Ribble Valley Borough Council
Housing & Development Control

Application no: **3/2021/0961**

Address: **Cowgill Farm Gisburn Road Sawley BB7 4LH**

Proposal: **Proposed demolition of an existing garage/store and the construction of one new self build, eco home with integral double garage.**

PROJECT NAME COWGILL FARM		
DRAWING NAME PROPOSED SITE PLAN FLOOR LEVEL		
PROJECT No 90.20	STATUS PLANNING SUBMISSION	DATE SEP 21
SIZE A1		SCALE 1:200
DWG No 06

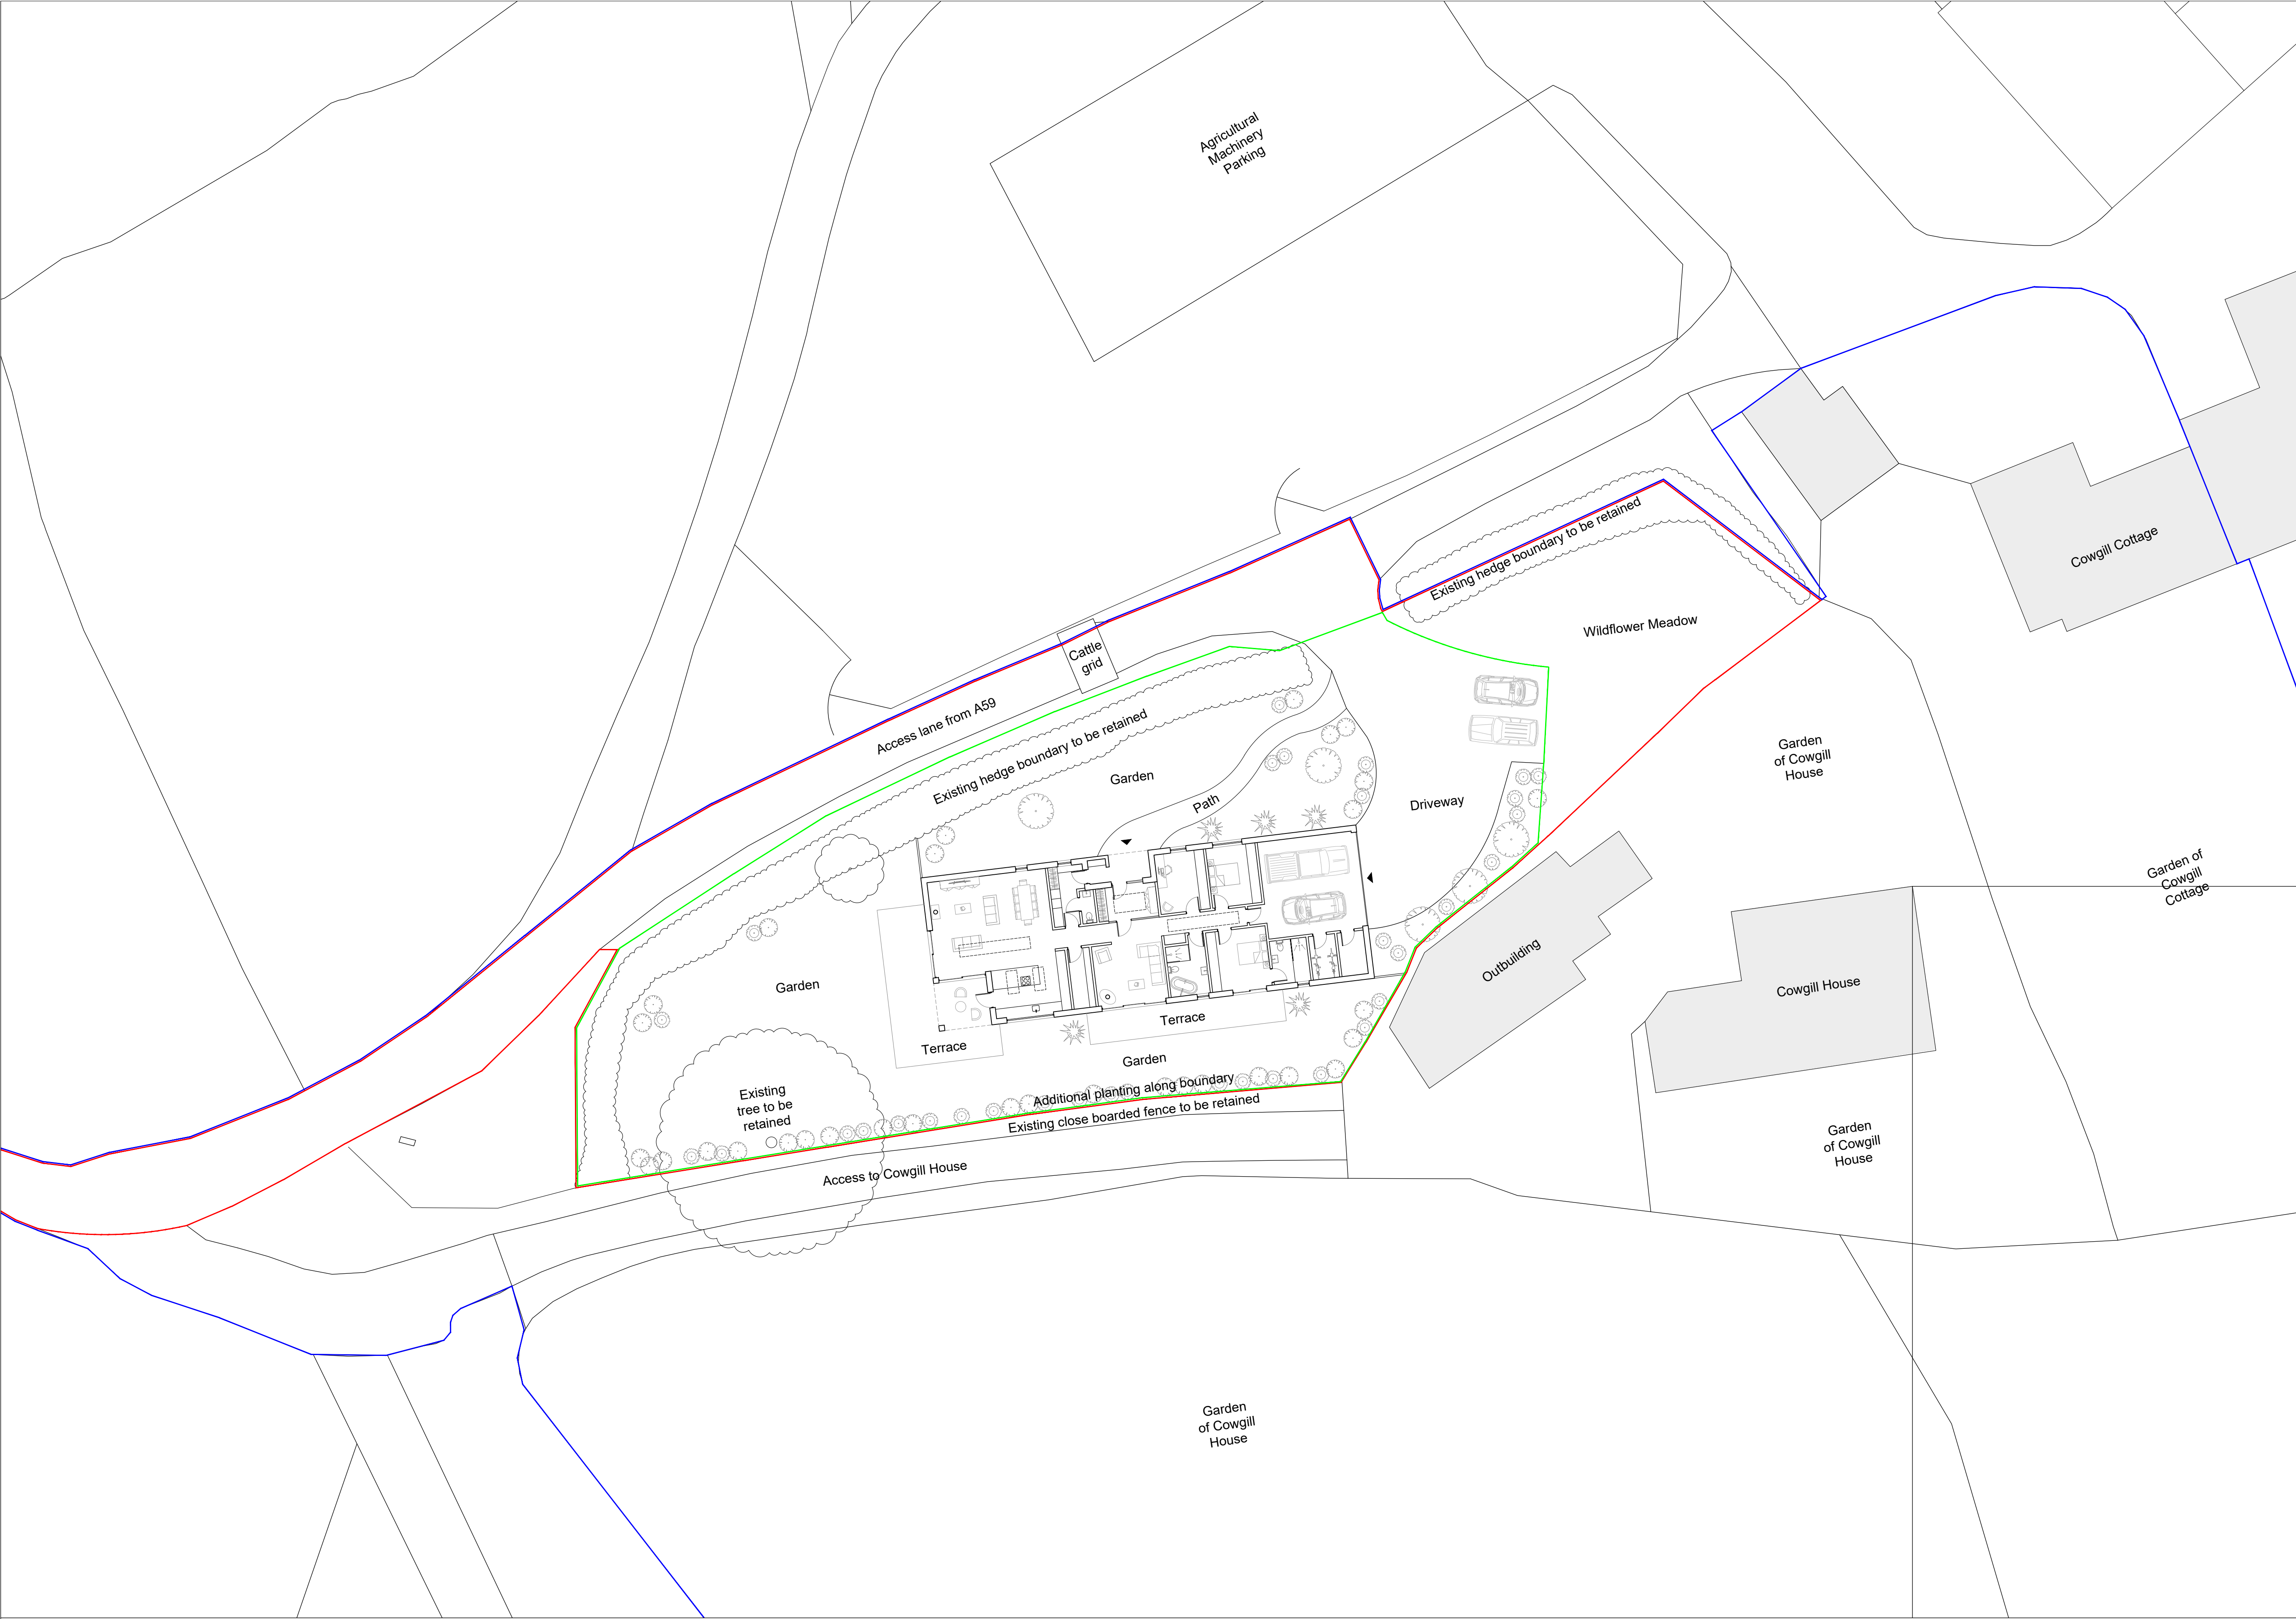
The LHA have reviewed ZMA drawing number 06 titled "Proposed Site Plan Floor Level" and are satisfied the parking arrangements complies with the LHAs guidance as defined in the Joint Lancashire Structure Plan and so the LHA have no comments to make.

1. The development hereby permitted shall not be occupied until such time as the parking and turning facilities have been implemented in accordance with ZMA drawing number 06. Thereafter the onsite parking provision shall be so maintained in perpetuity.
